Arun District Council
Arun Civic Centre
Maltravers Road
Littlehampton
West Sussex BN17 5LF
Planning & Building Control General Enquiries
Tel: (01903) 737756 Fax: (01903) 730442
Dx: 57406 Littlehampton
Minicom: 01903 732765
e-mail: planning@arun.gov.uk
website: www.arun.gov.uk/planning

Application No: EP/47/21/HH
Site Address: West House South Strand East Preston BN16 1PN
Description of works: Erection of second floor addition, part single storey side, part two storey front, side and rear extensions and alterations to fenestration/openings

Thank you for your internet representation made on 7th June 2021 which has been recorded as an objection with the comments as follows:

**EXISTING WEST ELEVATION.**

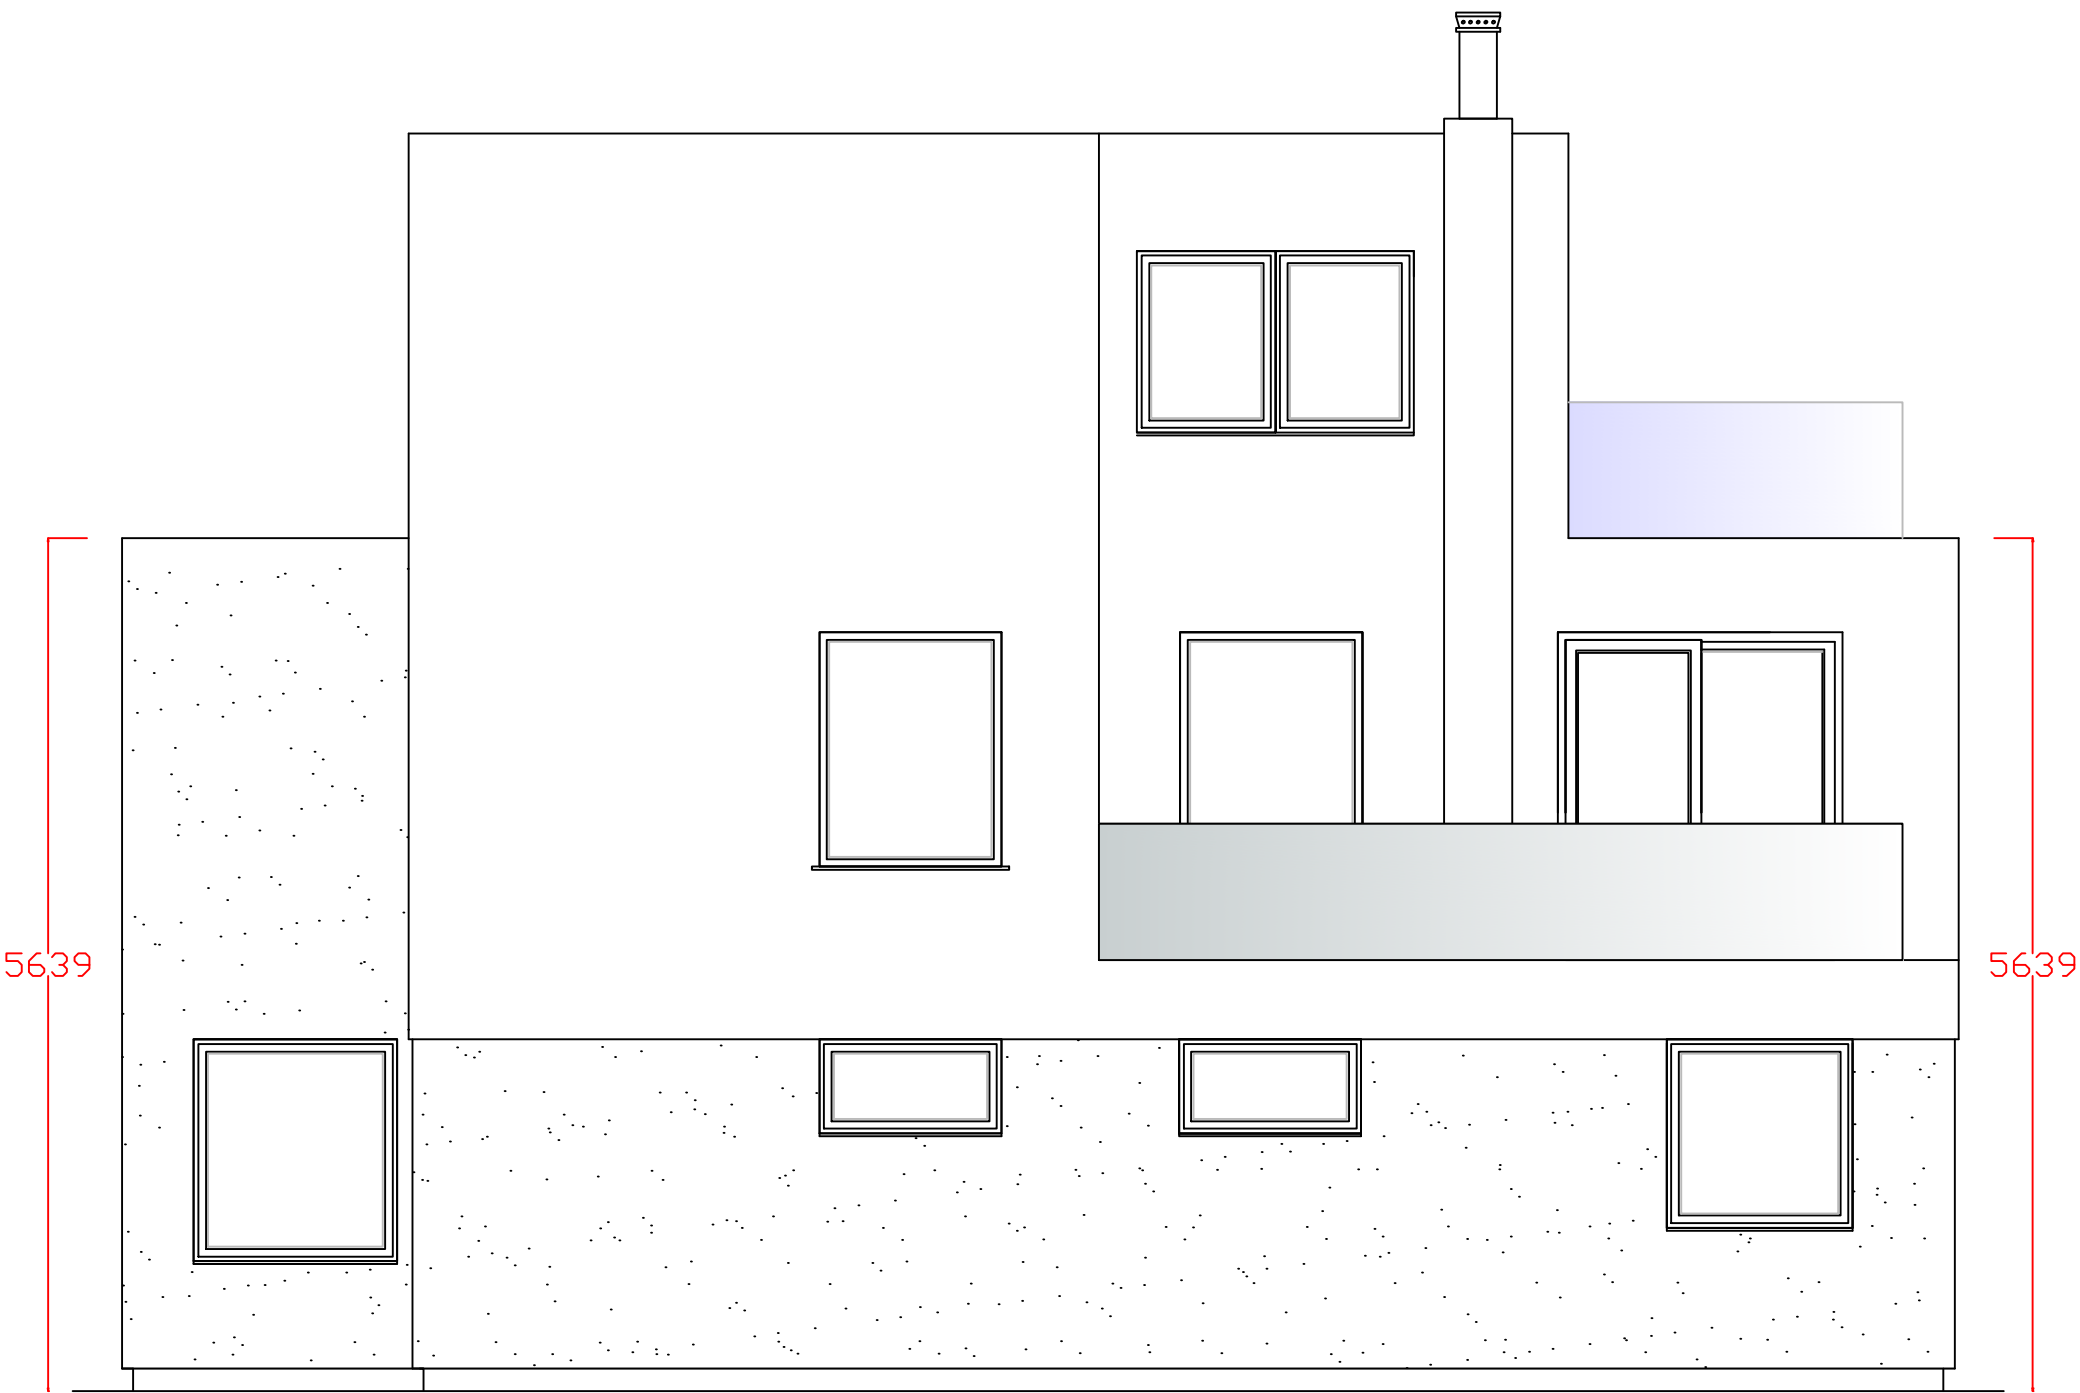
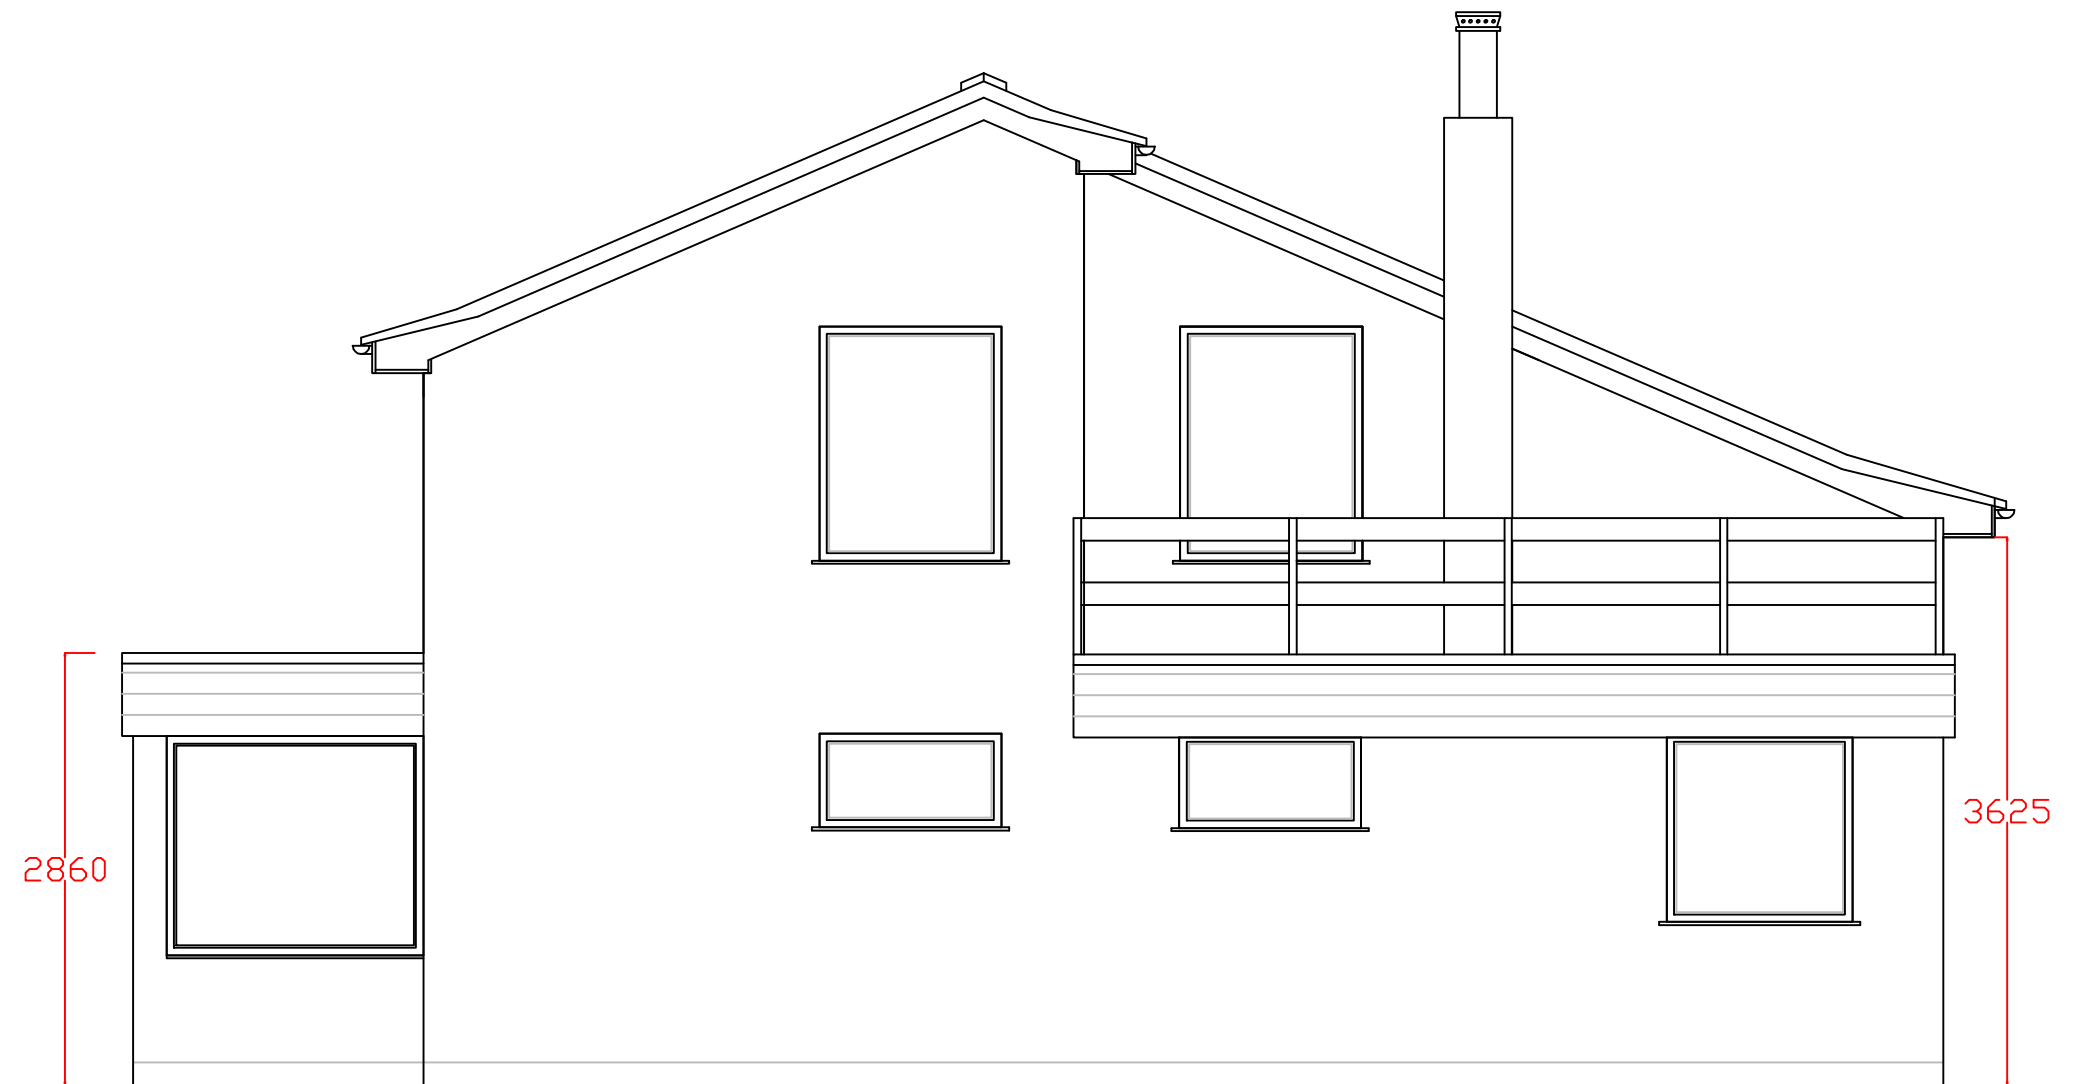
The latest block plan showing the proposed areas of development appears to be incorrect. The proposed first floor area shown hatched in blue should also show the additional floor space extending the full footprint of the building towards the southern boundary. This area as shown on the existing west elevation is currently a roof area that pitches away from the properties at the southern boundary approximately 5 meters away, even less at the western boundary. This roof was pitched like this to accommodate the stair headroom from ground to first floor, is not currently first floor habitable floorspace and was designed to not compromise the properties at the rear. The proposed red hatching appears to be set back towards the northern boundary and not as large as is shown on the floor plans. It also does not show the large, proposed balcony that is also shown on the floor plans and extends the full footprint of the building at the rear. This proposed additional third floor when

BLOCK PLAN

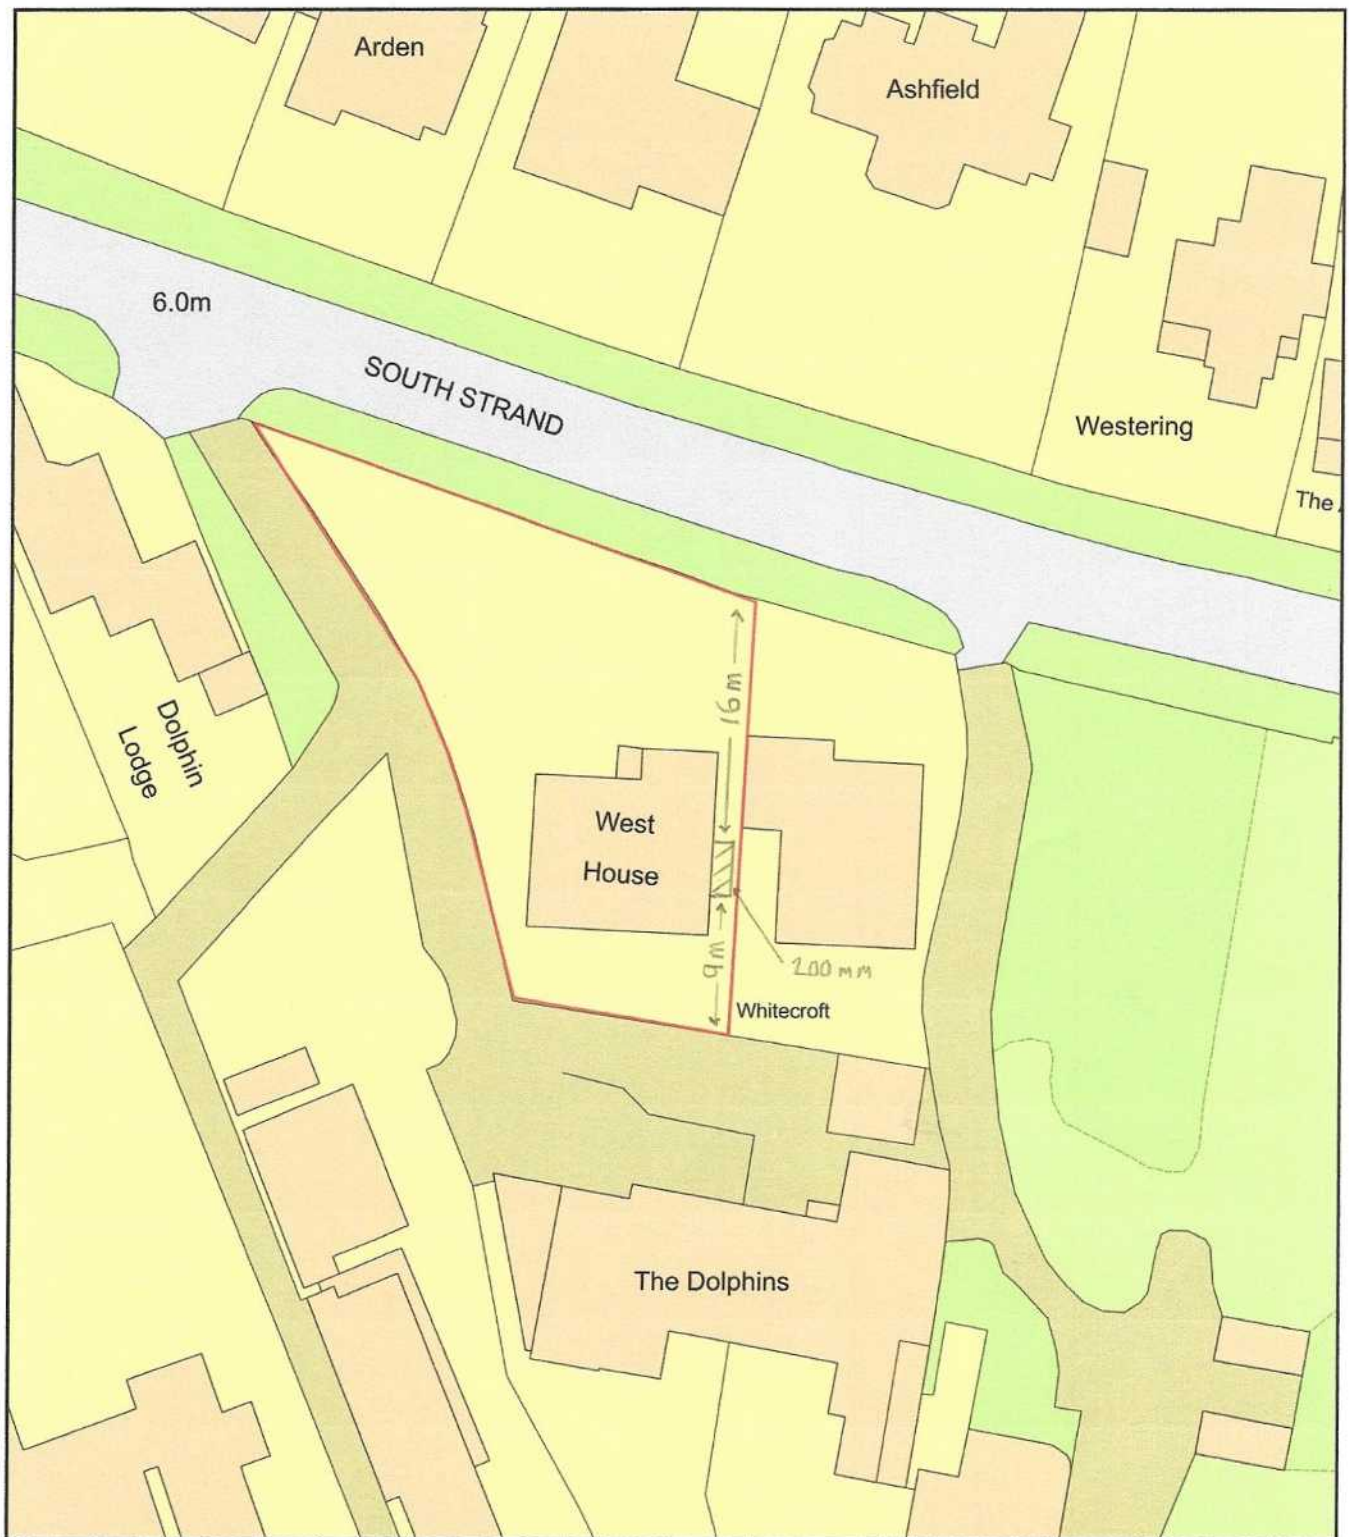
viewed from the beach will sit above all surrounding properties.
